WEST SUSSEX COUNTY COUNCIL CONSULTATION

TO:	Arun District Council FAO: Michael Eastham
FROM:	Stephen Gee Highways, WSCC
DATE:	13/09/18
LOCATION:	Broadlees, Dappers Lane, Angmering, West Sussex, BN16 4EN
SUBJECT:	A/114/18/PL Demolition & erection of 70 bed care home within Use Class C2 (replacing building 4 approved by A/27/16/PL), access, parking, landscaping and other associated works.
DATE OF SITE VISIT:	
RECOMMENDATION:	☒ Advice ☐ Objection ☒ Modification ☐ No Objection ☐ More Information ☐ Refusal
S106 CONTRIBUTION TOTAL:	£ See below for breakdown.

Appendix E – Proposed Pedestrian Infrastructure

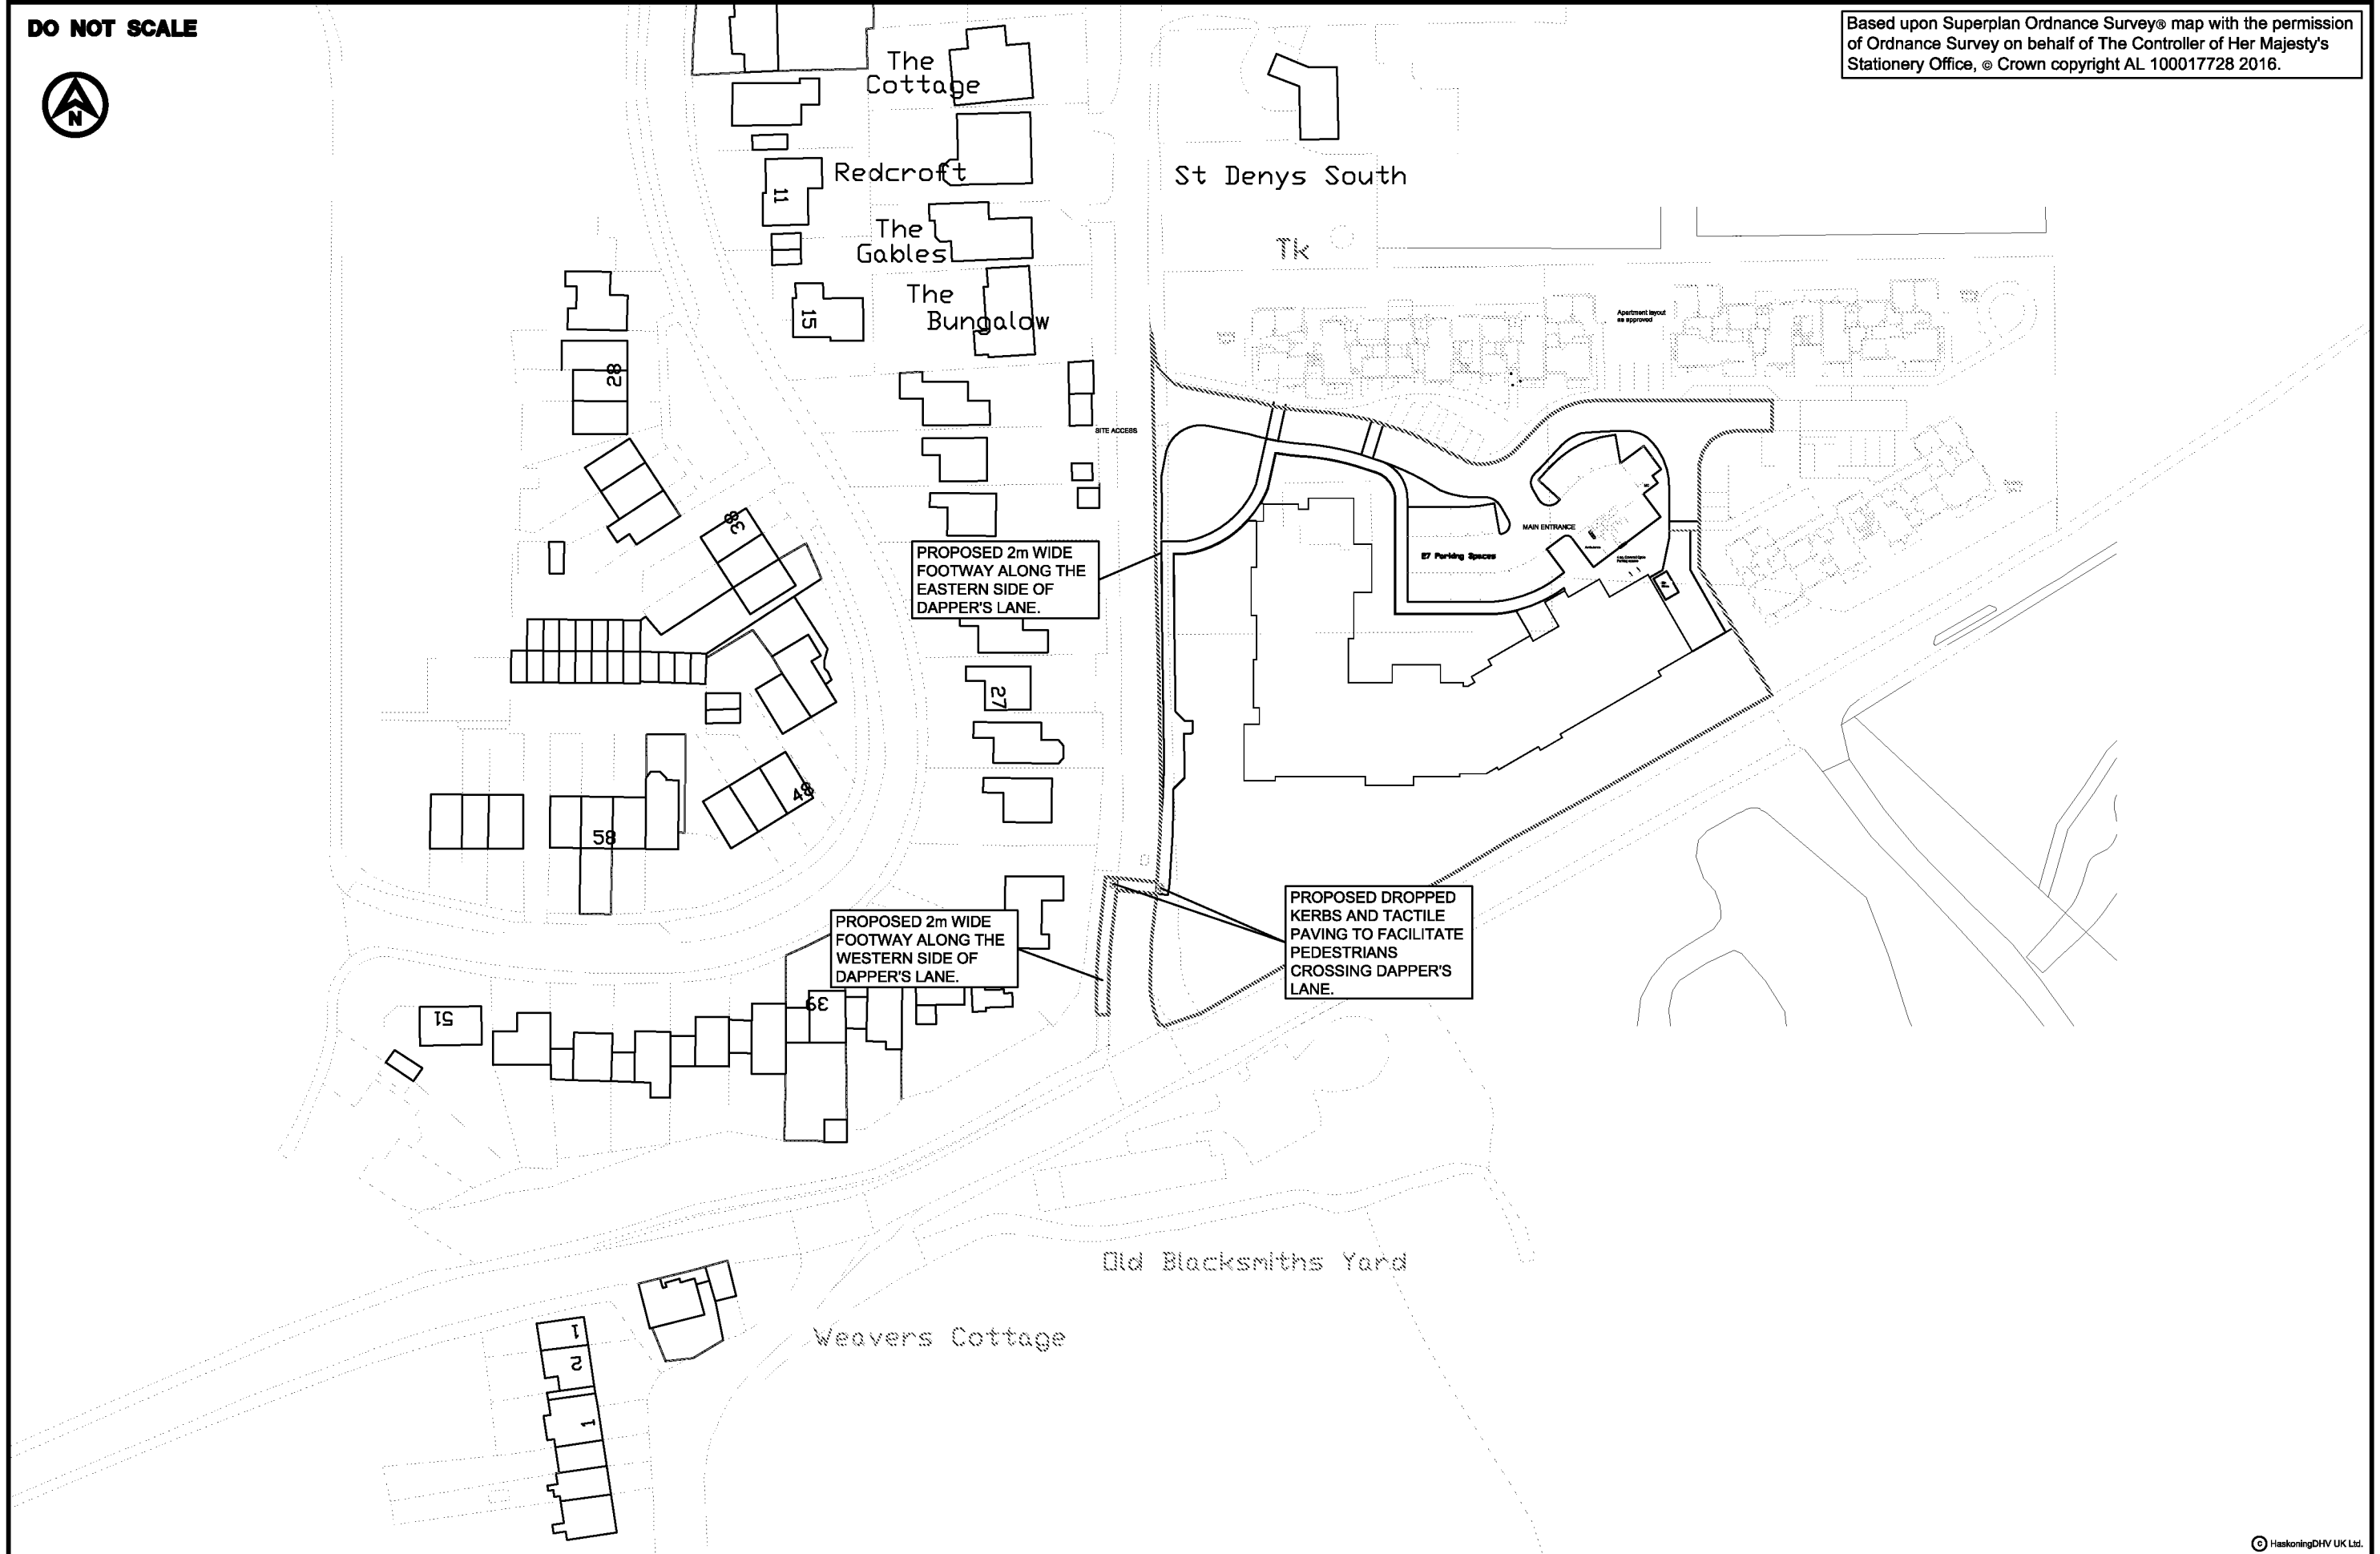
As part of the consented development the applicant is to provide a 2.0m footway from the site access south alongside the existing grass verge and informal pedestrian crossing with tactile paving, dropped kerbs before extending further south on the eastern side of the carriageway to meet the existing provision. (as shown on drawing PB7693-SK01)

It is recommended that the proposals are modified to include provision of a footway along the southern boundary of the site (both red and blue line boundary) and the travel plan is revised to incorporate the above comments.
